Application for a non-material amendment following a grant of planning permission.

Approval of reserved matters following outline consent P/58/15/OUT for 90 No. dwellings. Also seeking to address the terms of planning conditions 6 (Phasing), 8 (ecology), 9 (Surface Water), 12 (Vehicular Access), 15 (Parking), 18 (Travel Plan), 20 (Landscape Management), 24 (Parking Control), 25 (Dwelling Parking) and 26 (Materials).

Reference number:	P/70/19/RES
Date of decision	28/02/2020

Change the Public Open Space lighting from mains fed lighting columns / bollards to solar powered lighting columns / bollards

Sheet: 1/1	Scale: NTS	Rev: A
---------------	---------------	-----------

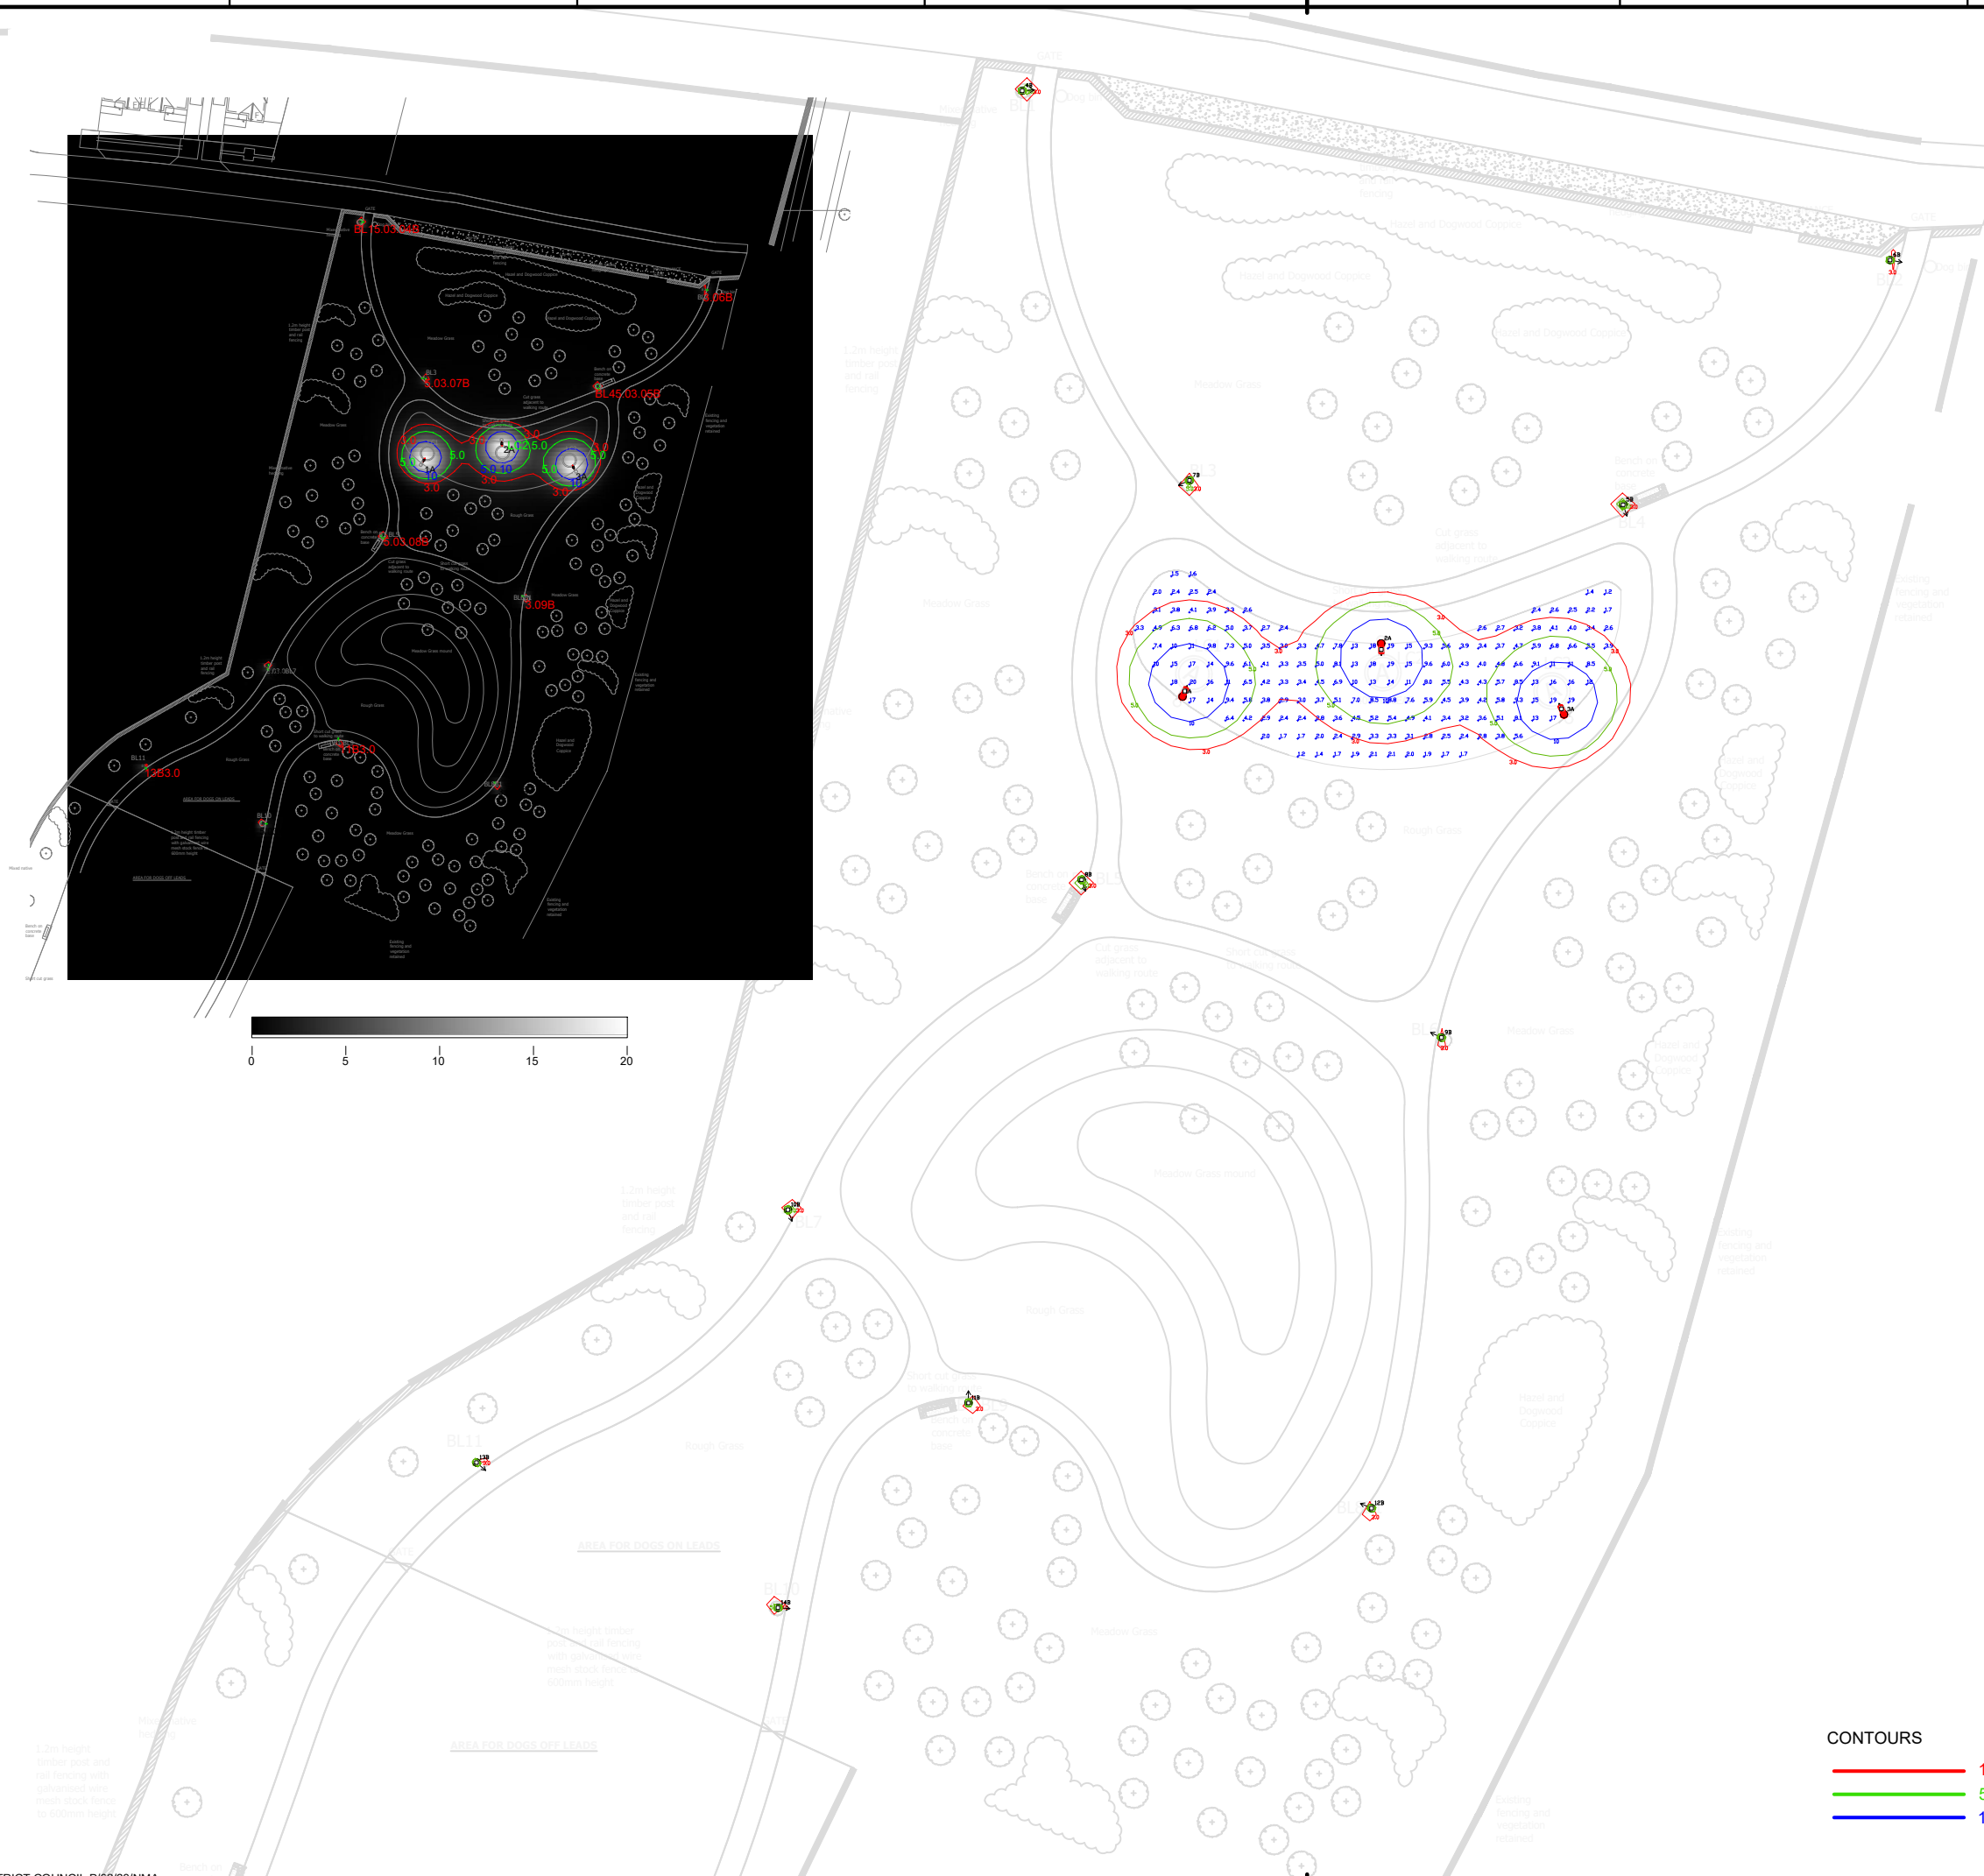
Proposed Lighting Layout 100046.PRIV.1300.1301 Rev P01
Outdoor Lighting Report 1000090.POS.001 Rev A

Prolectric Lighting Design 2020056 Rev A
